Application for Planning Permission for Works or Extension to a Dwelling

Development: Hip to gable roof extension with front and rear dormers and new front porch.
Location: Tinkersbell Hook Lane Aldingbourne PO20 3TE

Existing South Elevation

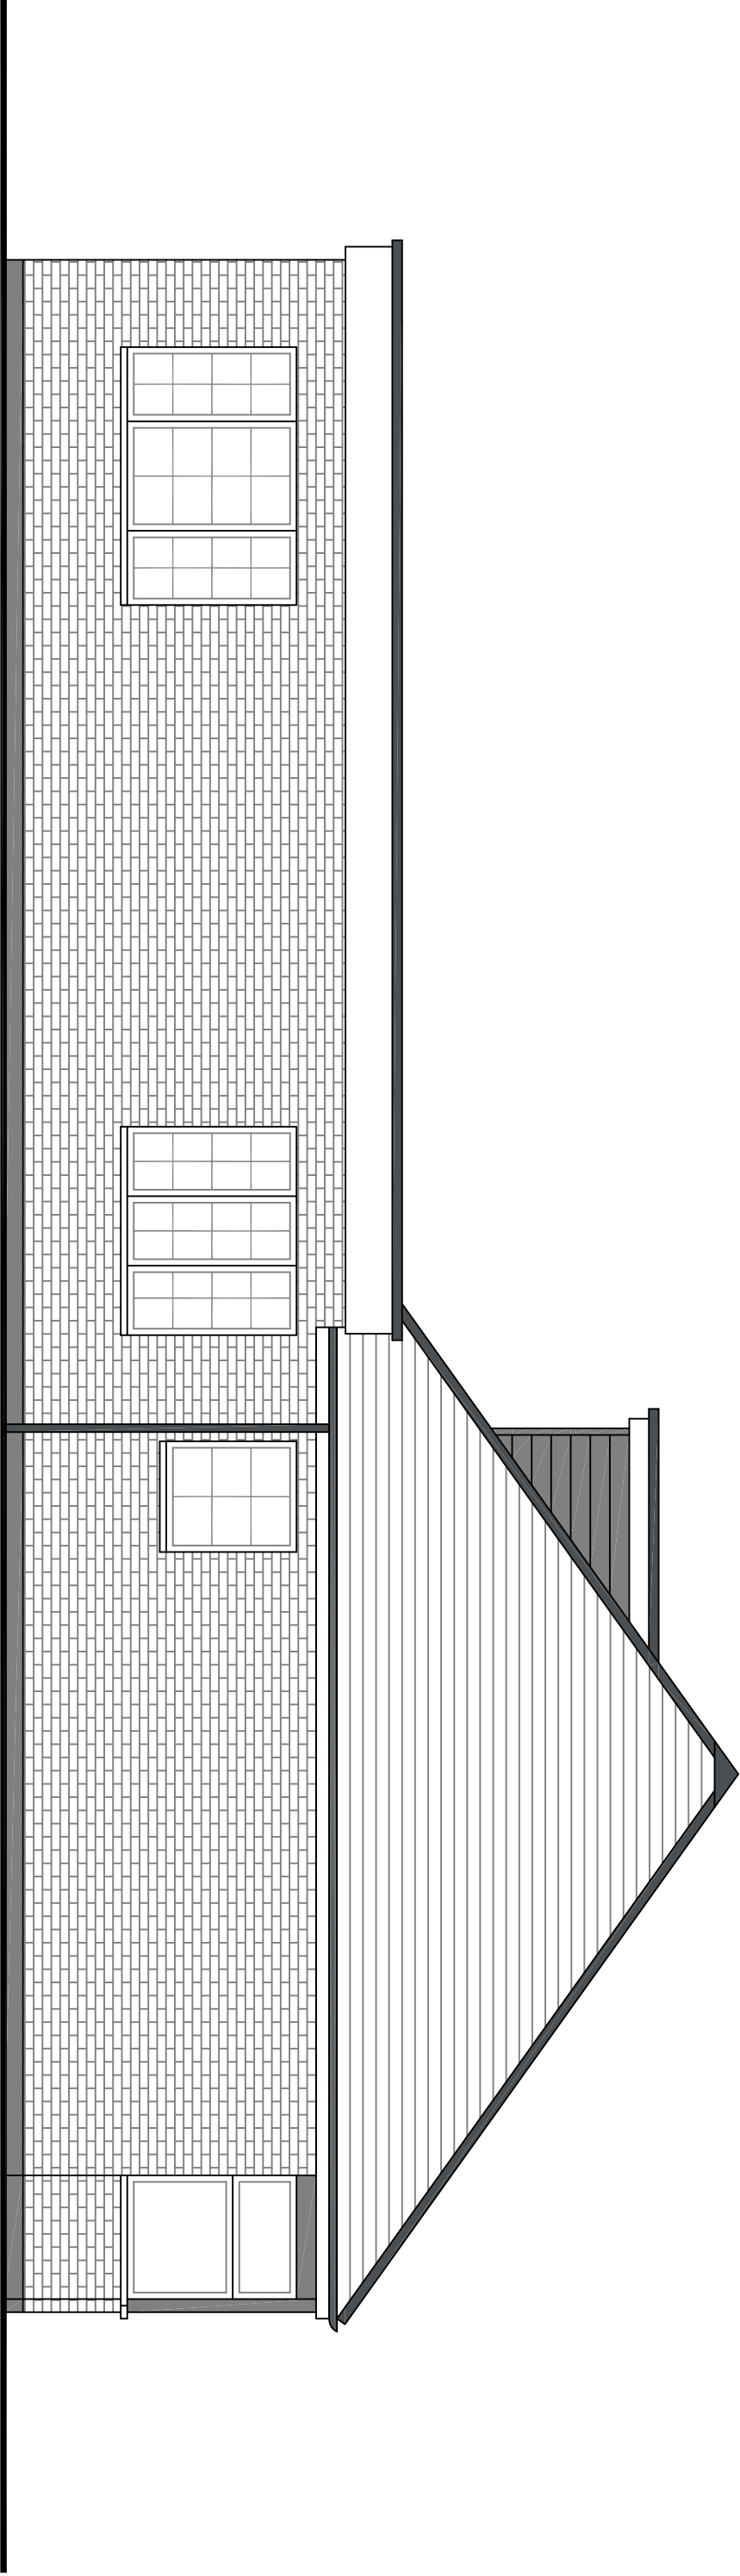
The existing south elevation windows have inconsistent dimensions compared to the existing ground floor plan.

The elevation and floor plans all require a scalebar. Plans with more than one drawing should have

separate scalebars/scales if they are not of the same scale.

Existing Roof Plan

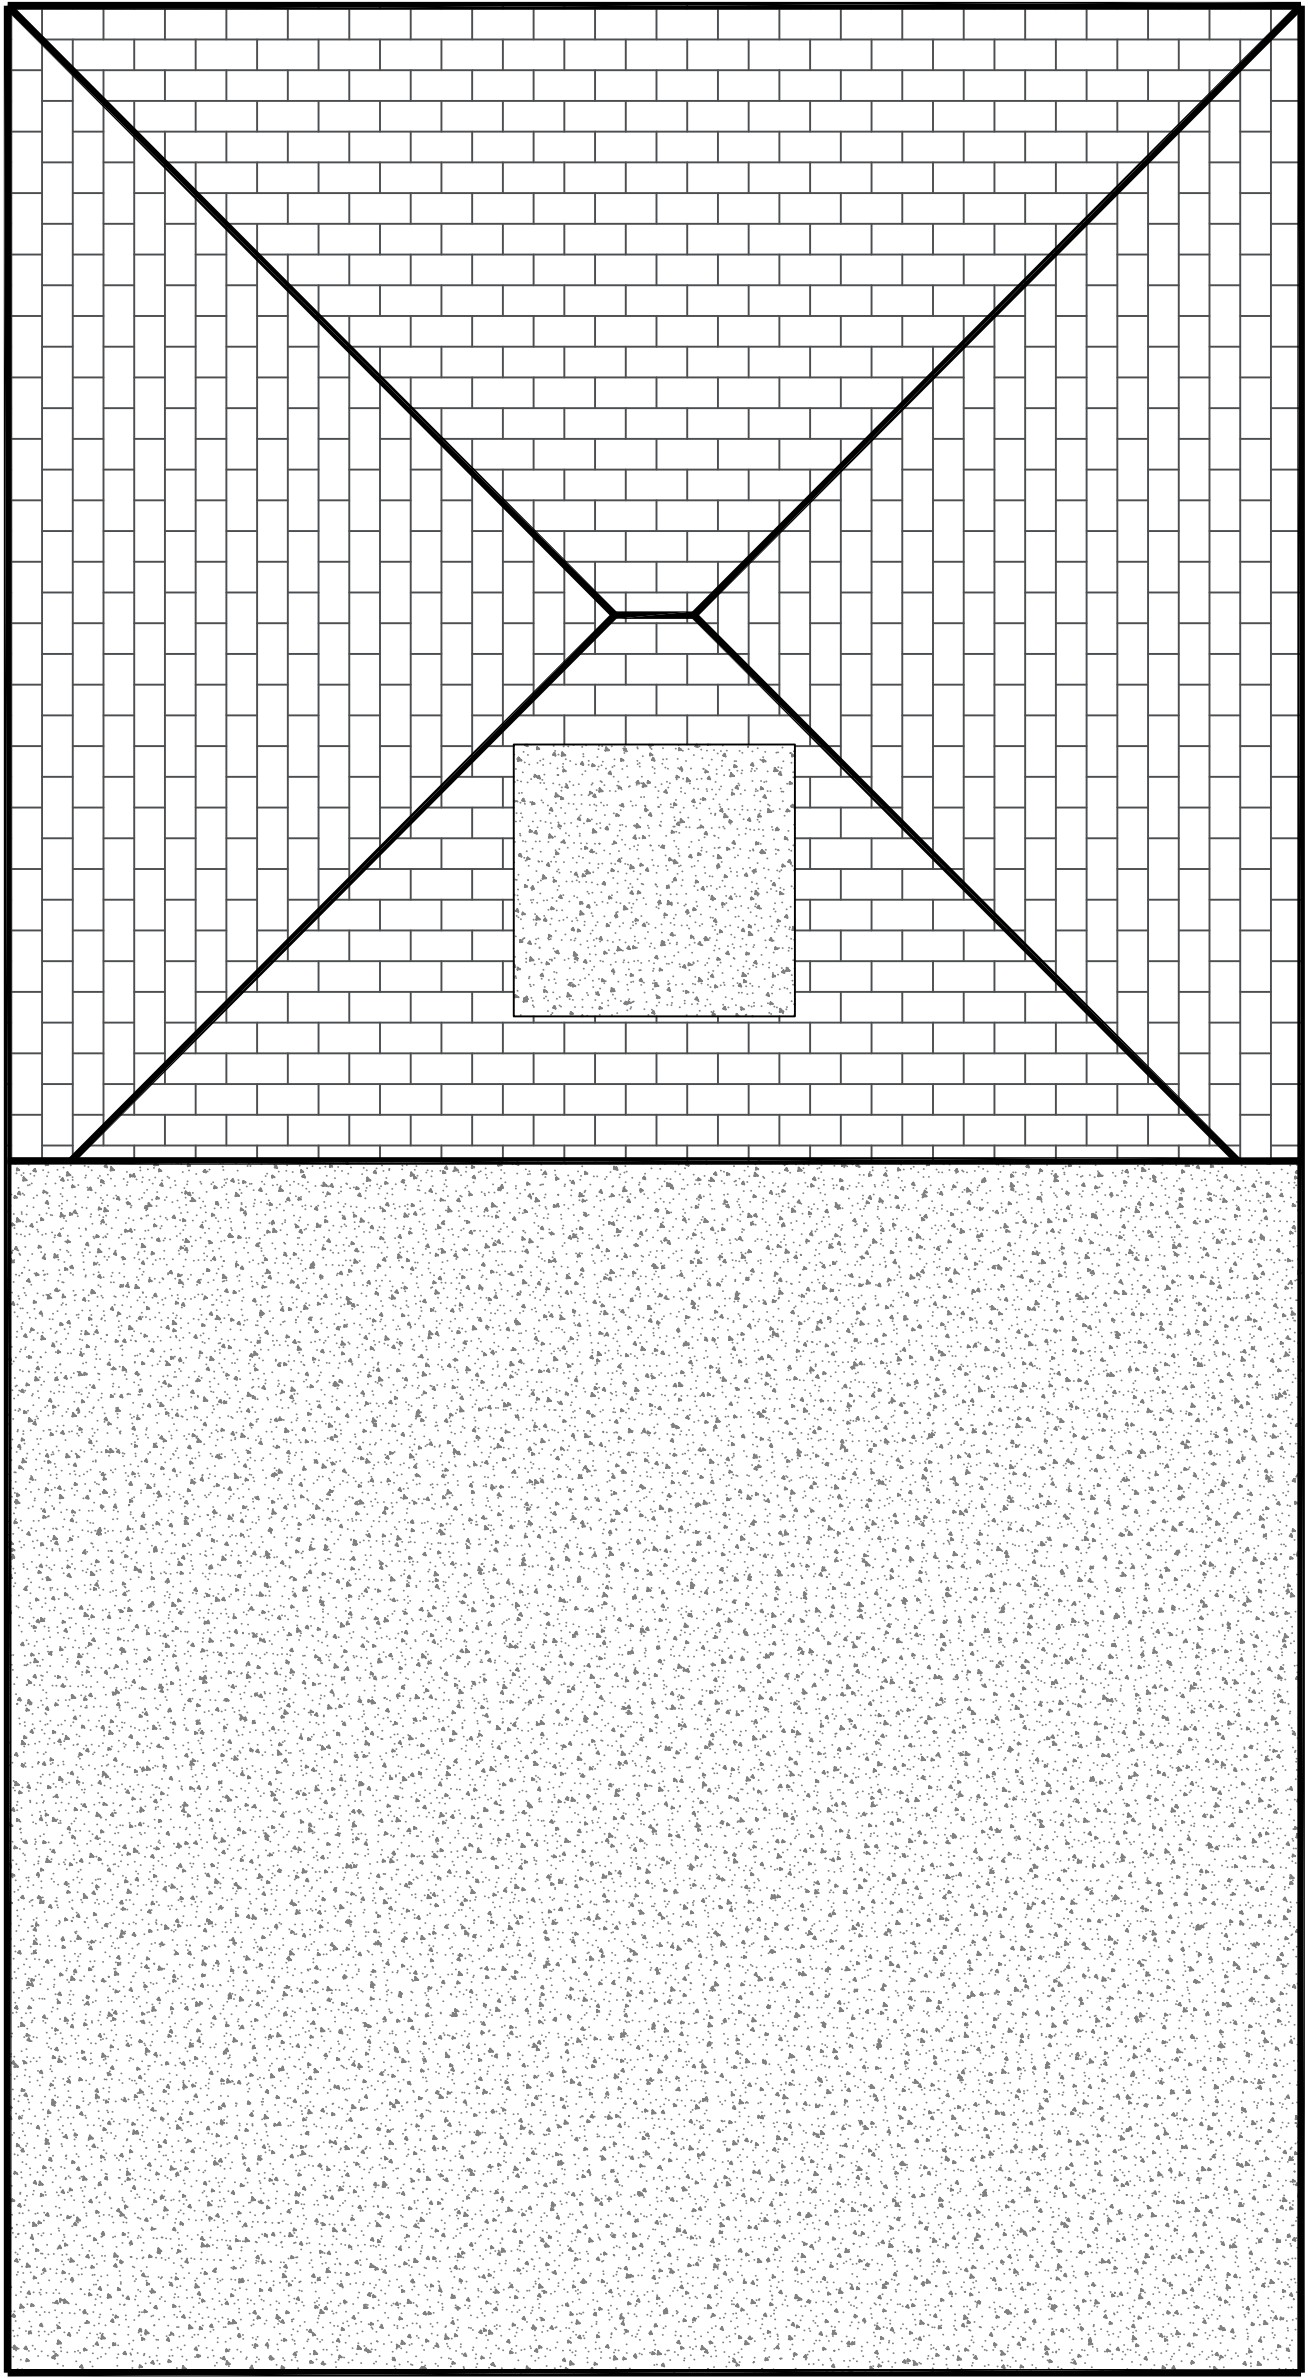
The location plan requires a scalebar and the scale should be of 1:1250, this plan should be existing and be consistent with the existing roof plan.
